**Consultation Response from KC,
Conservation and Design**
2022/90656 Manor House, Manor Street, Dewsbury, WF12 8ED
Change of use, alterations and erection of additional storey extension to training / learning centre to form 14 residential units and management office
Date Responded: 12.05.2022
Responding Officer: Sebastian Pickles
Responding Ref:

sections as proposed

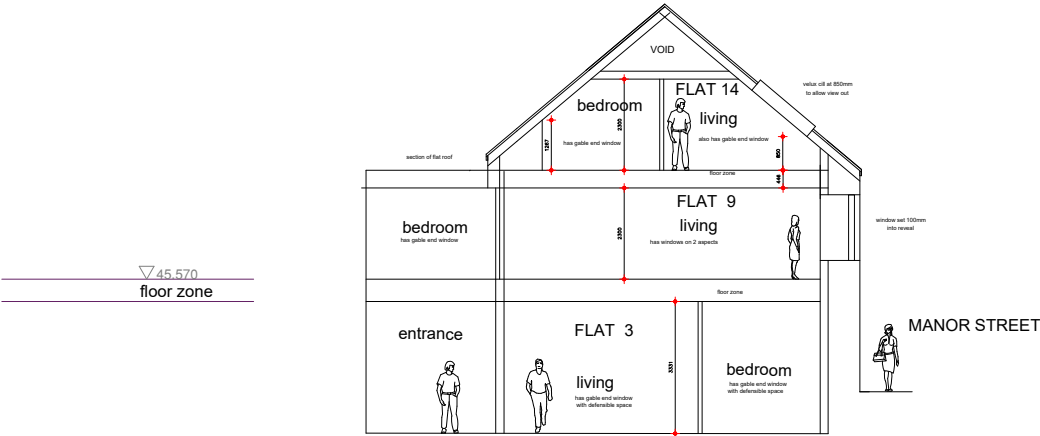
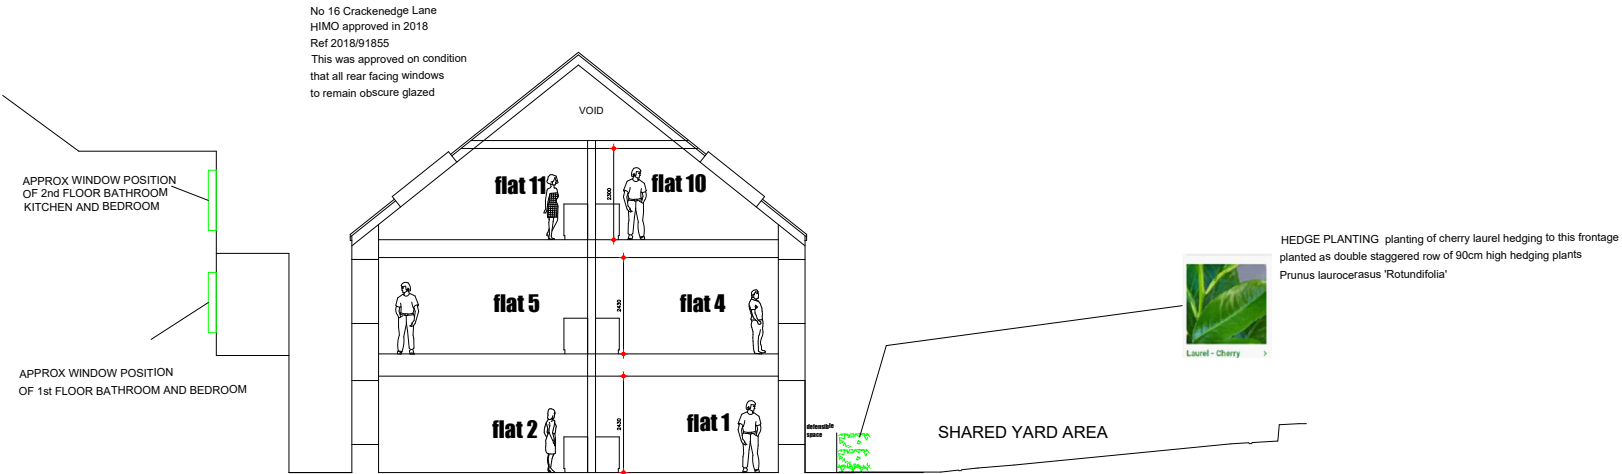
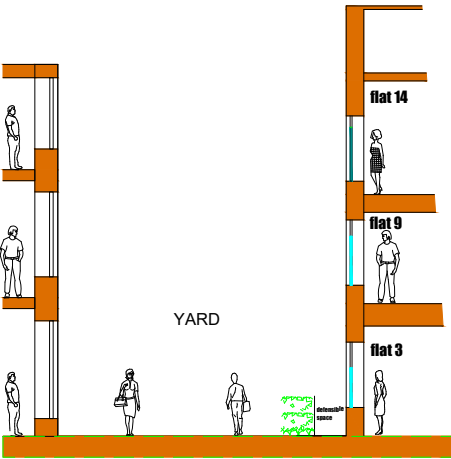
Conservation would raise no concerns with the change of use of the building. The proposals however see the alteration and extension of the existing pitched roof linear building, with a slight increase in height and alteration of the roof pitch. This would create an intrusive roof which would project and be entirely visible off Crackenedge Lane and more visually intrusive on Manor Street. The proposals also include the increase to the flat roof section and addition of a step pitch.

Conservation consider that the existing pitch to the mill building should be retained as existing. This would also ensure some mitigation to the proposed insertion of roof lights to the western roof plane.

The increase/ addition to the flat roofed elements is considered reasonable. However, we would again set out that the pitch of the roof should be reduced and height to match that of the existing pitch of the mill building. The proposed increase would create an overly intrusive addition and given the roofscape of the surrounding area it would be entirely disproportionate. Again the reduction in pitch would provide mitigation to the proposed roof lights to the most eastern roof plane.
